# Rezoning Transportation Analysis

Petition Number: 2023-046

Date	Description
08-25-23	First Review (NK)
09-20-23	Second Review (NK)
11-22-23	Third Review (TP)

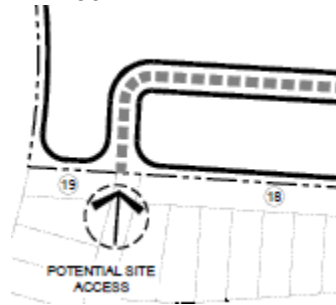
7. ~~**Outstanding Issue 8/24/23:** Remove this intersection, and ensure all future horizontal curves meet the minimum CDOT standard of 150' radius.~~

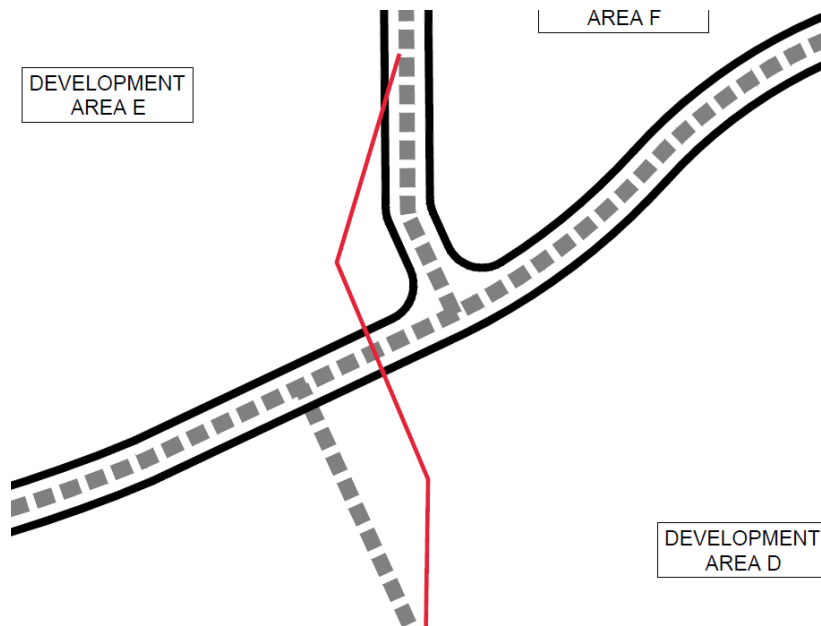
8. ~~**Outstanding Issue 8/24/23:** Align internal public roads to remove offset intersections.~~

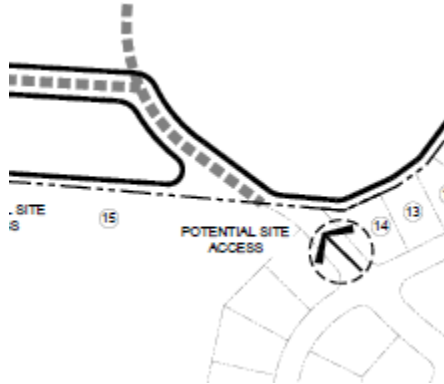
9. ~~Outstanding Issue 8/24/23:~~ The horizontal curves pictured below need to have a minimum 50' separation to meet minimum CDOT standard.
